0908/4.01
22 October 09
Your ref:- EP/144/08/

Proposed Erection of 1 new bungalow. Land west of Cedar wood, The Street and South of 11 Copse View, East Preston, BN16 1AY.

Application for a non-material amendment following a grant of planning permission.

North Elevation

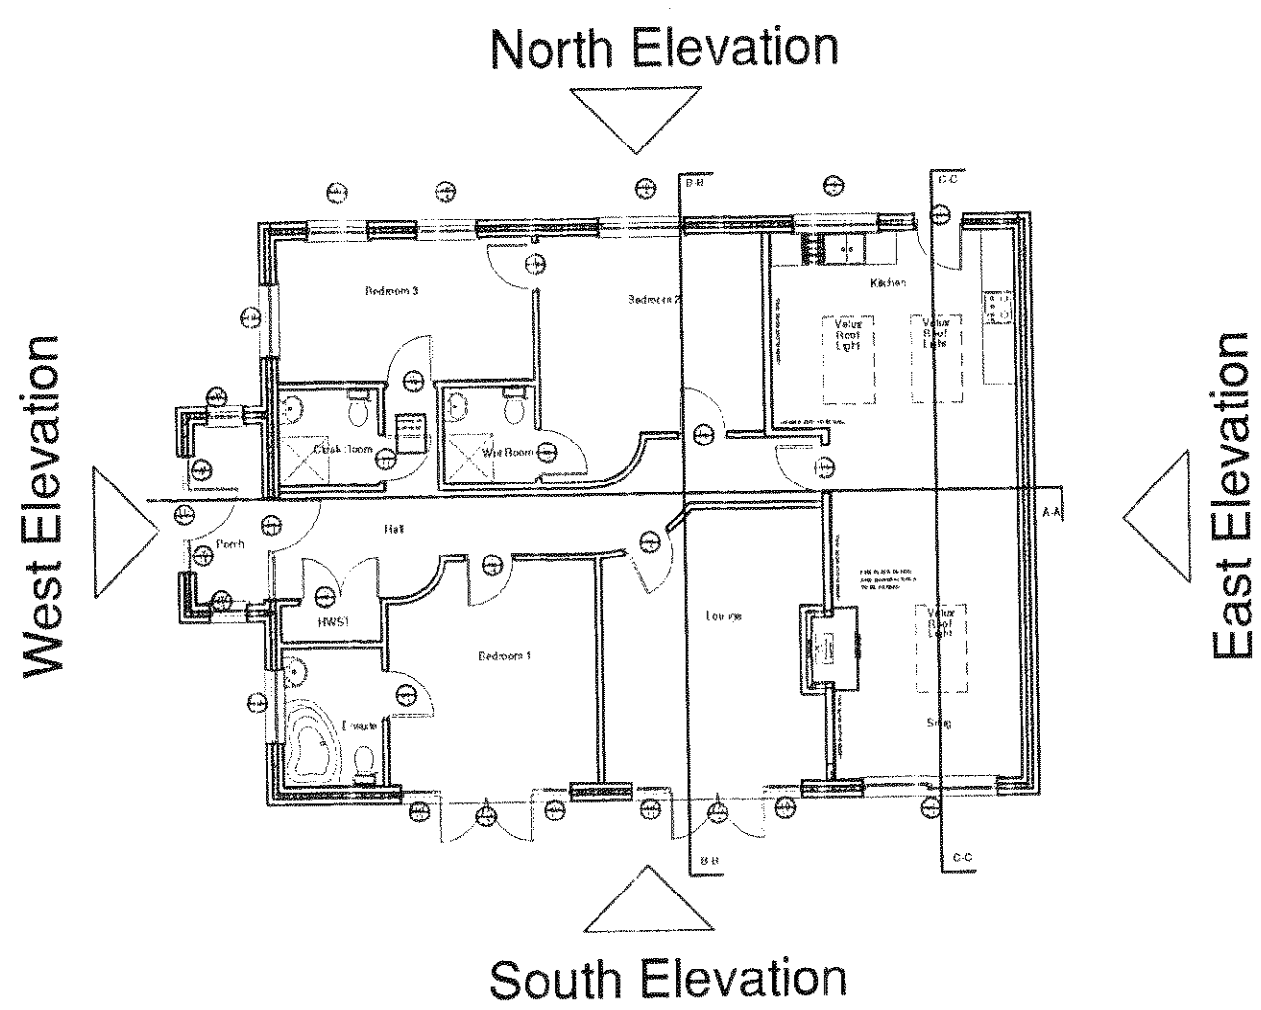
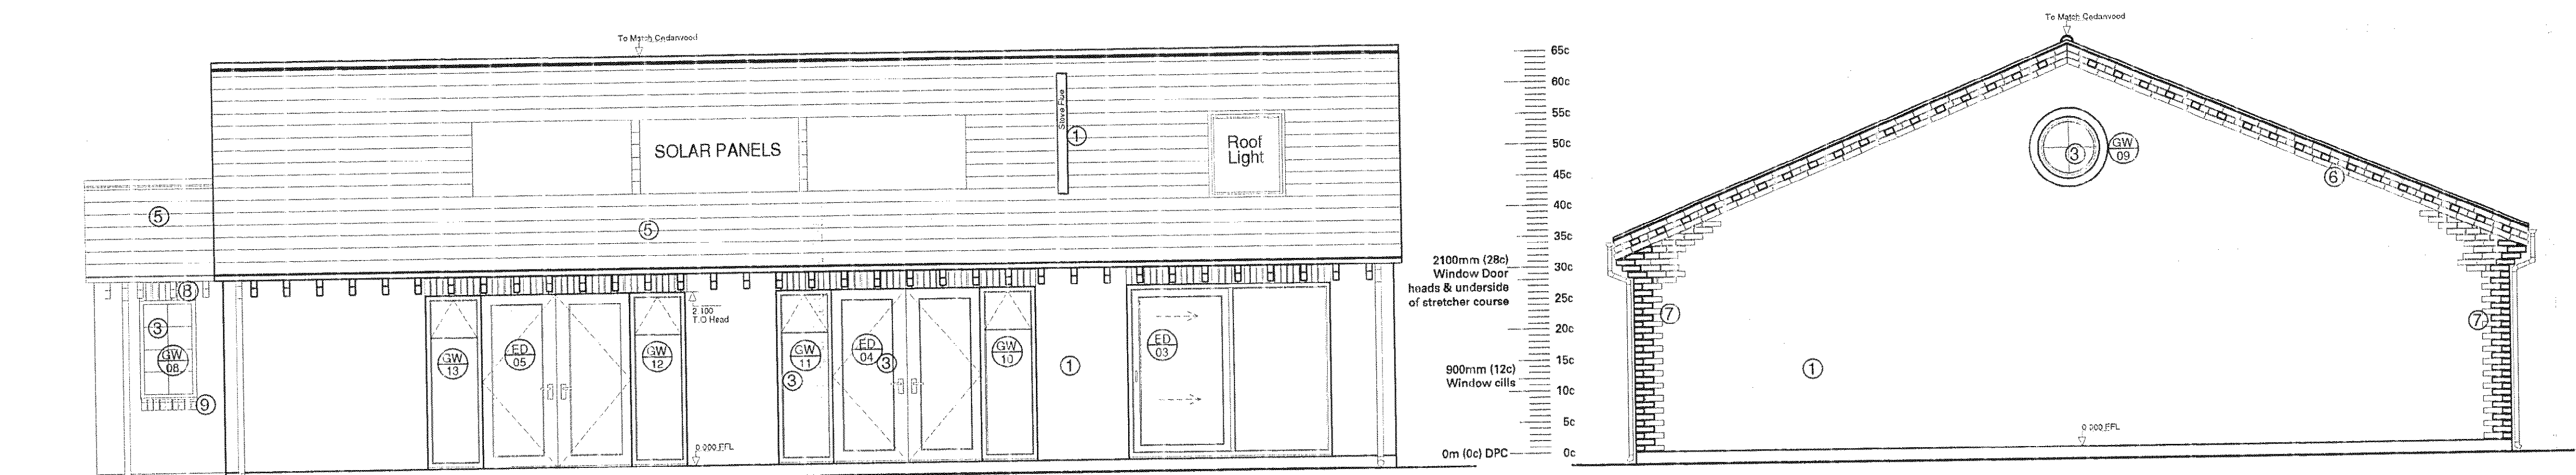
The client has requested that he would like to make a minor amendment to the north elevation by introducing 2 central brick quoin details to break up the elevation. I have enclosed a copy of the revised drawings which show the additions.

ADDITION OF 2 X QUON DETAIL TO NORTH ELEVATION.
BRICK

THE PROPOSAL INVOLVES IN THE INTRODUCTION OF 2 X QUON DETAILS TO THE NORTH ELEVATION TO BREAK UP THE RENDER WALL.

AL (0-)03E PROPOSED ELEVATIONS
